ASSESSMENT REPORT

Section 75W Modification Upgrade of Coca-Cola Amatil Training Facility Building & Signage Briens Road, Northmead

DRAWING NO. S. 01
 SCALE 1:200@A3/1:200@A1
 DATE: NOVEMBER 2009

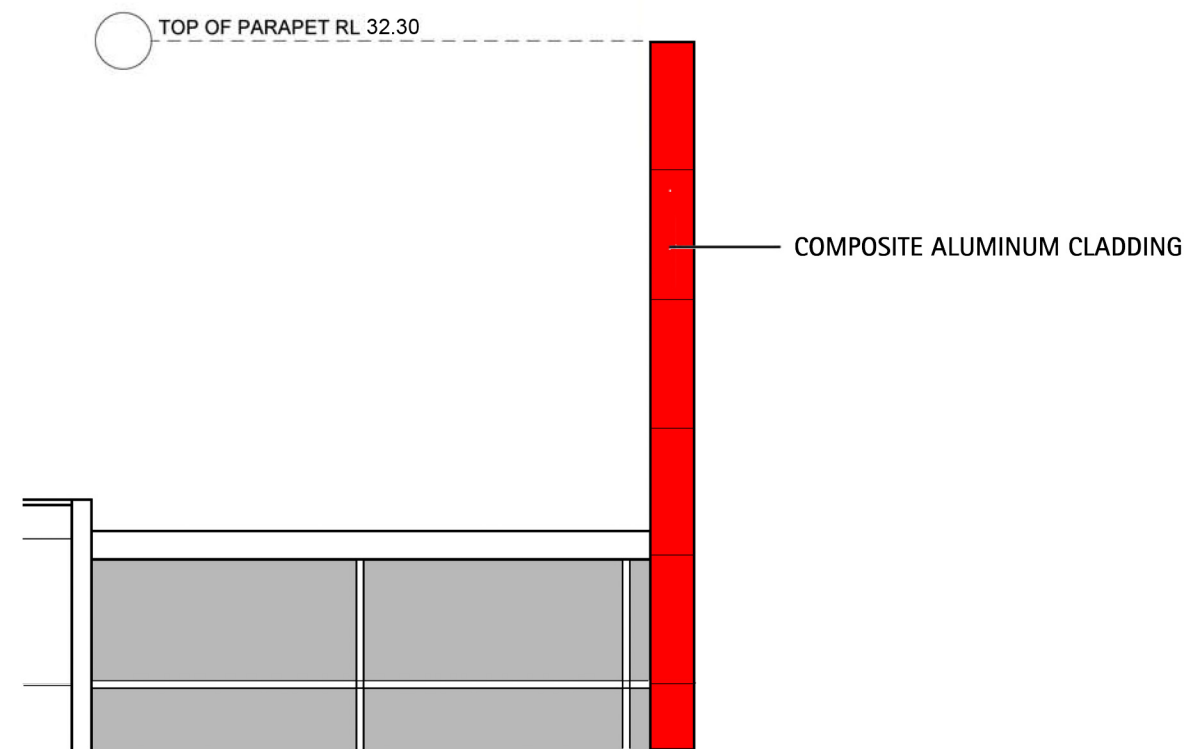
The Department has reviewed the amended modification in regard to *State Environmental Planning Policy No.64 - Advertising and Signage* and considered issues raised by Council. The Department considers the proposed signage meets the definition of *business identification sign* under the SEPP and is therefore not considered advertising signage. The proposed signage would identify an approved structure as belonging to the Coca-Cola site, would consist of a single business logo and 'ribbon' panel, and would not include general advertising of products, goods or services.

Notwithstanding, the Department does not consider the continual illumination of the Coca-Cola logo warranted and recommends that an illumination curfew, similar to that placed on the High Bay Warehouse logos, be applied to the facility building logo.
